Planning Application No: 3/2023/0803

Proposal: Proposed single-storey extension to rear.

Location: 16 The Woodlands Brockhall Village Langho BB6 8BH

The submitted documents and plans have been reviewed and the following comments are made.

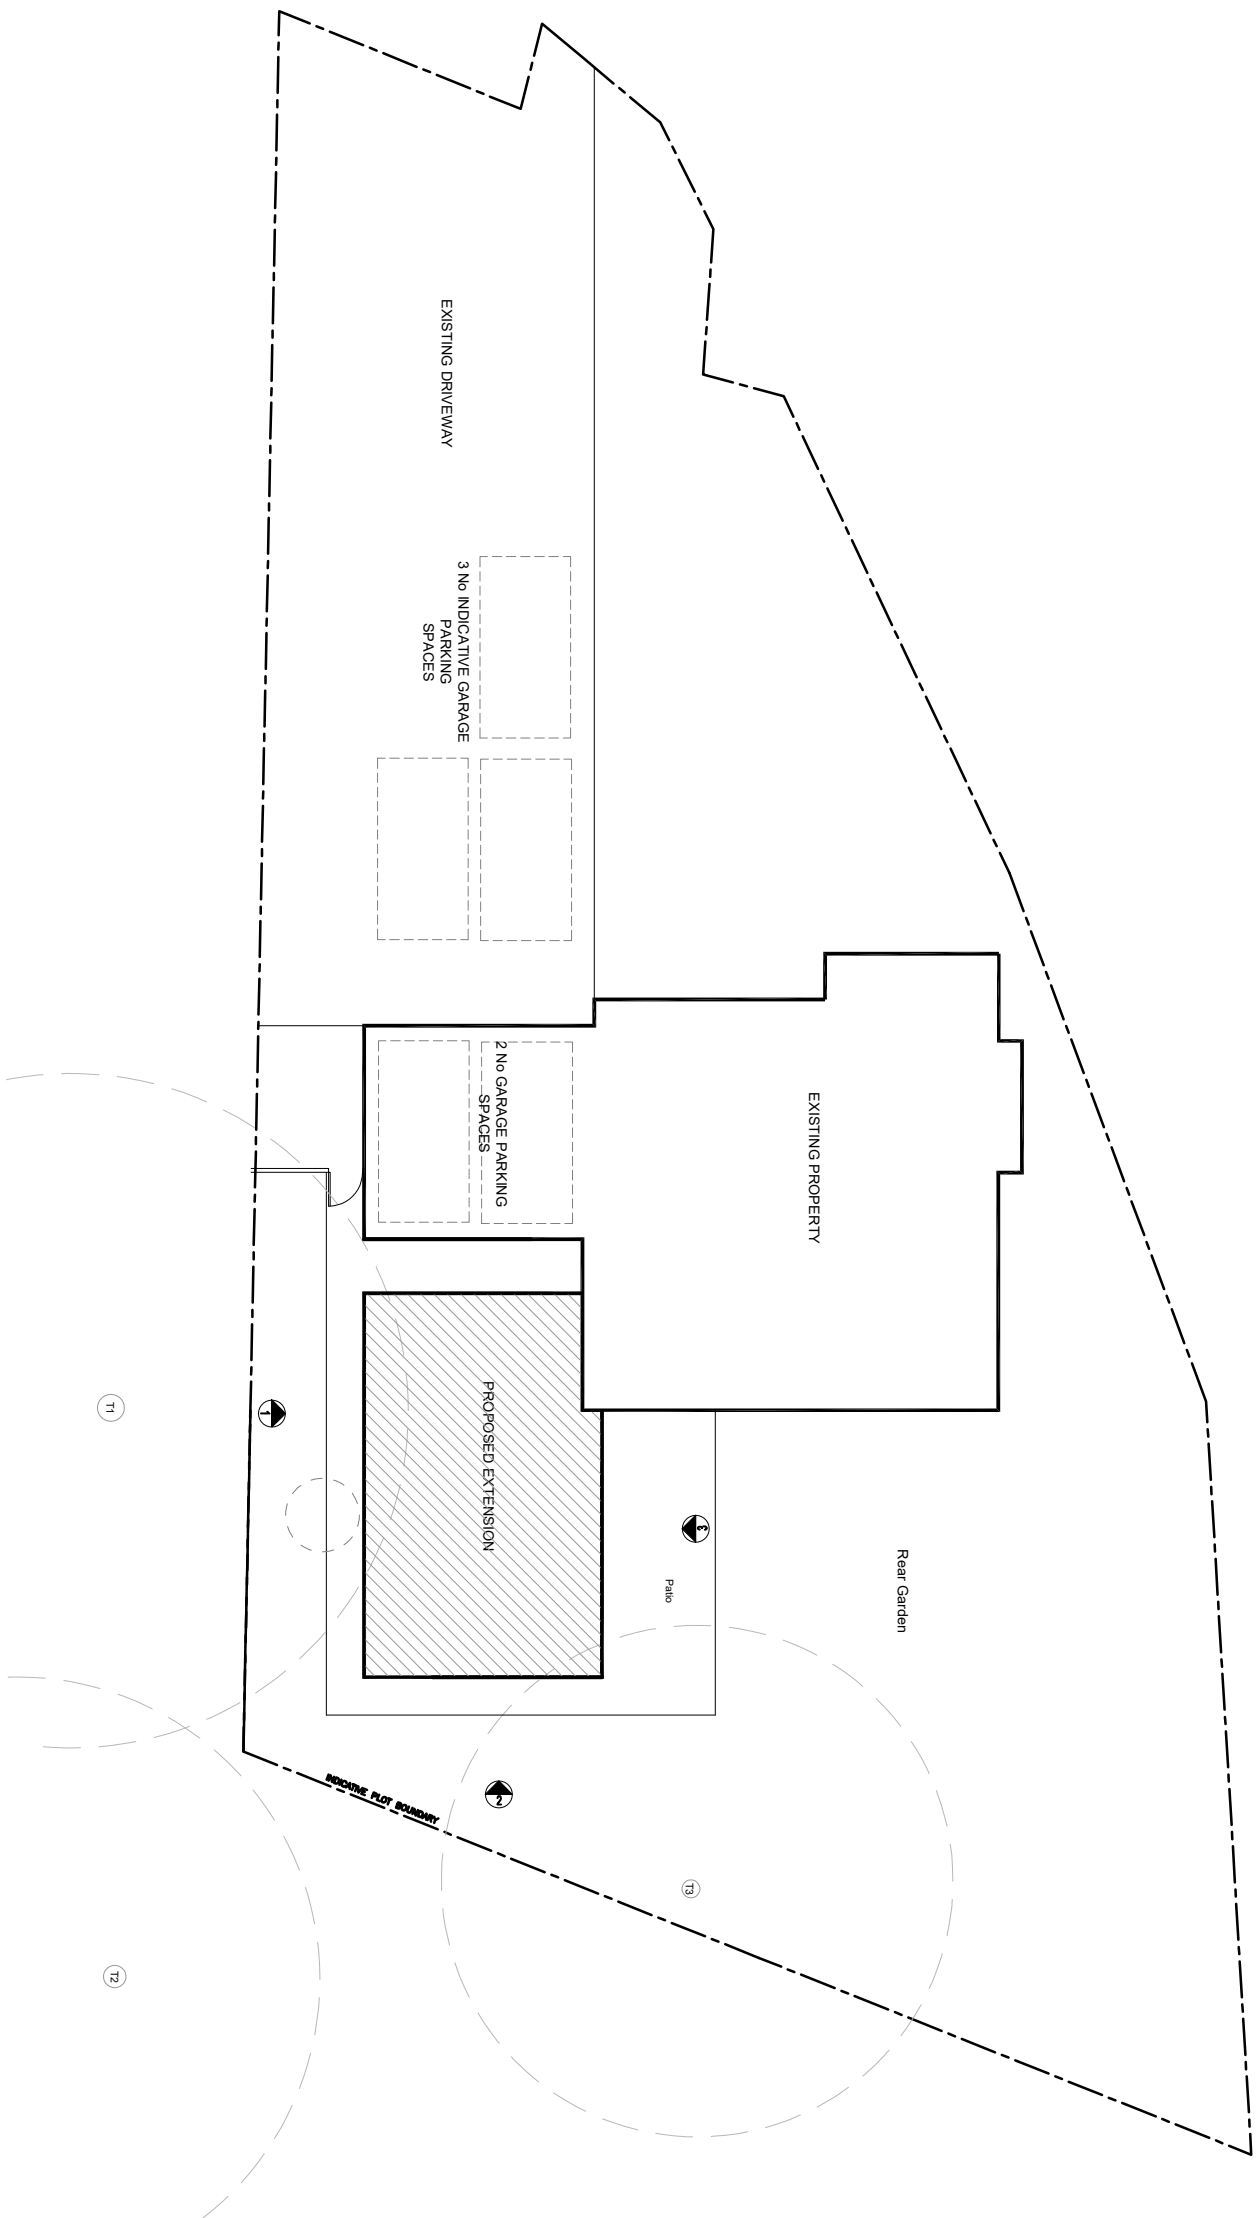
No parking plan has been submitted. A parking plan is required to show that the proposal meets the required parking standards.

Parking on a turning head is not acceptable for highway safety reasons.
